### **EPA Advice on Environmental Impact Statement**

Thank you for the request for advice from Public Authority Consultation (PAE-9405812), requesting the review by the NSW Environment Protection Authority (**EPA**) of the Environmental Impact Statement (**EIS**) for the proposed Central Sydney Industrial Estate incorporating the Sustainable Road Resource Centre (SSD-10459) (**the Proposal**) at part Lot 100 DP 1168951 known as 9 Devon Street, Rosehill, NSW, 2142 (**the Premises**).

The EPA has conducted a review of the information provided for the Proposal including the EIS prepared by Element Environment Pty Ltd and dated 18 September 2020, and the associated documents.

RECONOMY AREA PLAN
SCALE 1:100

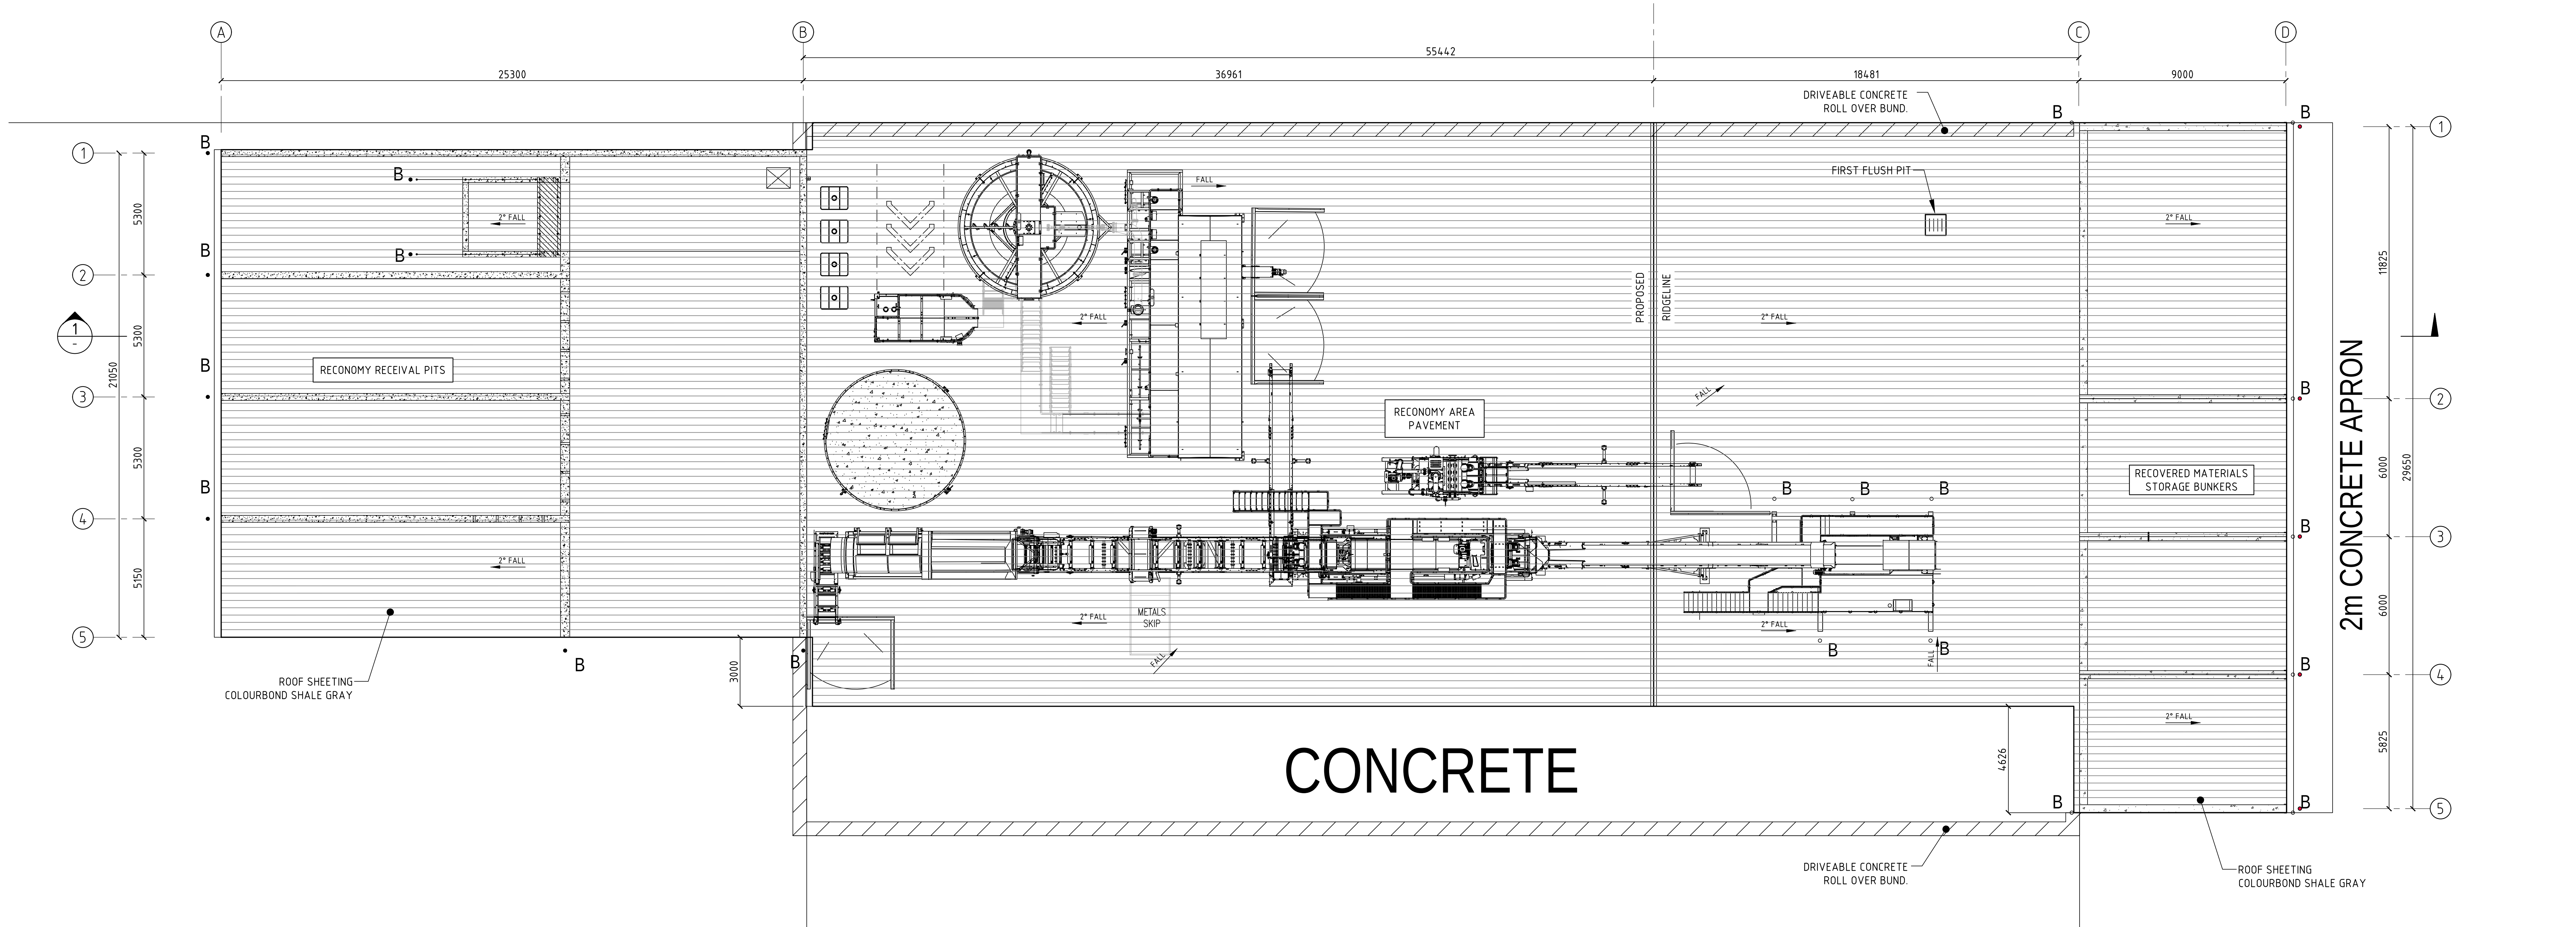
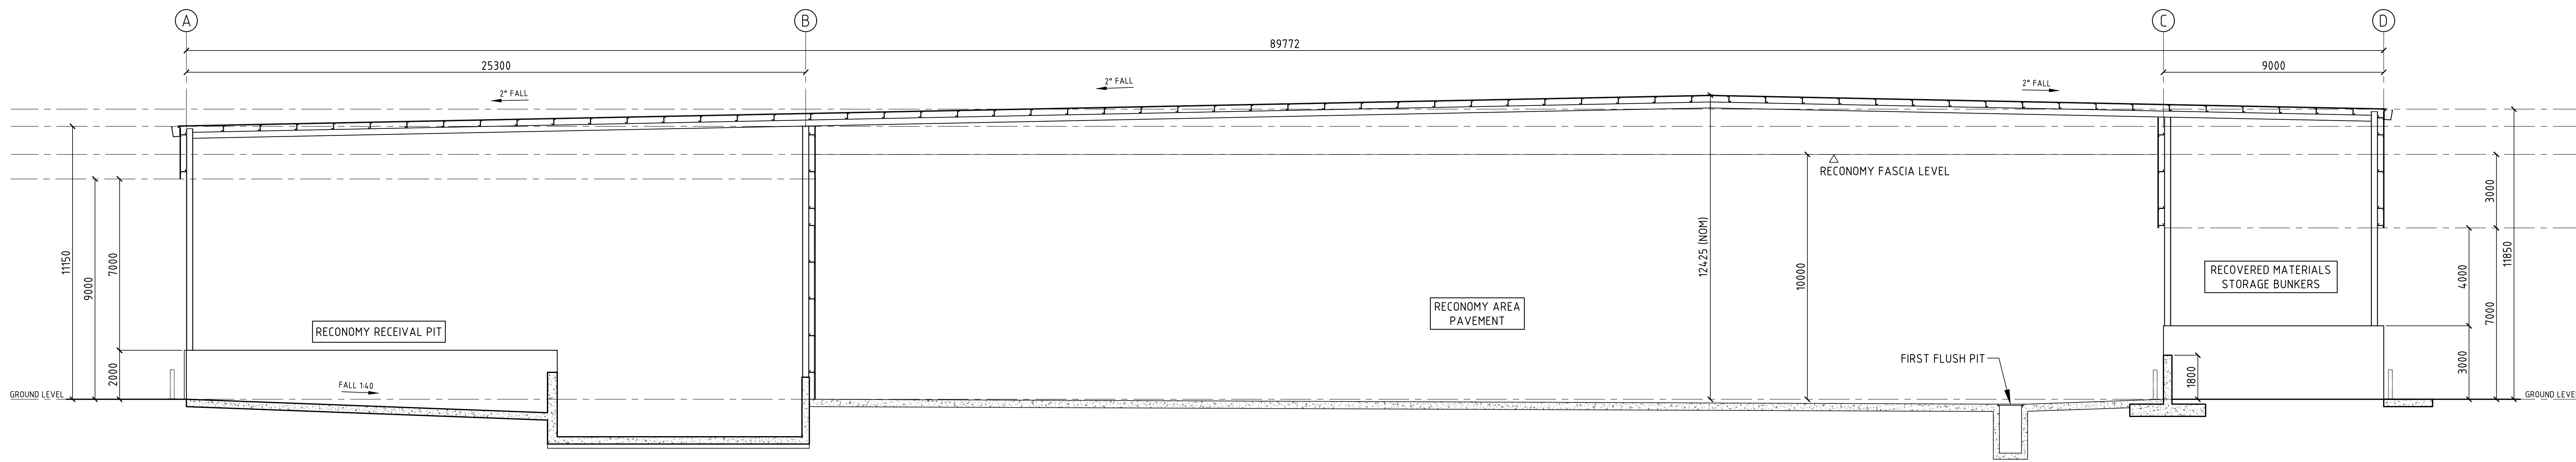
The EPA notes that the SEARs advised that the EPA expects facilities at the Road Resource Centre to be enclosed and that all waste and material handling activities including receipt, sorting, processing, sampling, quarantine, storage, and loading must be conducted within an enclosed building. This is best practice for all new facilities to ensure the minimisation of pollution and to improve environmental outcomes. However, the Proposal in its current form proposes for a number of activities to be conducted outside. The EIS does not provide any justification or explanation for why the Proposal does not include the complete enclosure of all facilities and why all waste and material handling activities are not proposed to be conducted internally as required by the SEARs.

The EPA notes that a licensed Reconomy facility is currently operating at 1A Unwin Street, Rosehill. The EIS states that the current Reconomy facility is proposed to be replicated at lot 6 of the Premises. However, the Reconomy facility located at 1A Unwin Street operates within a fully enclosed building and the Reconomy facility at lot 6 is proposed to be outside. As a result, the proposed facility will be decreasing its environmental performance by removing environmental controls which is in direct opposition to the objects of the POEO Act.

The Applicant must revise the Proposal to ensure all facilities are fully enclosed and no waste or material activities are conducted externally. If this is not feasible, the Applicant must provide detailed

justification for each proposed external activity and how, for each activity and the overall site, the Proposal will achieve similar environmental outcomes to all facilities and waste and material handling activities being conducted inside fully enclosed buildings.
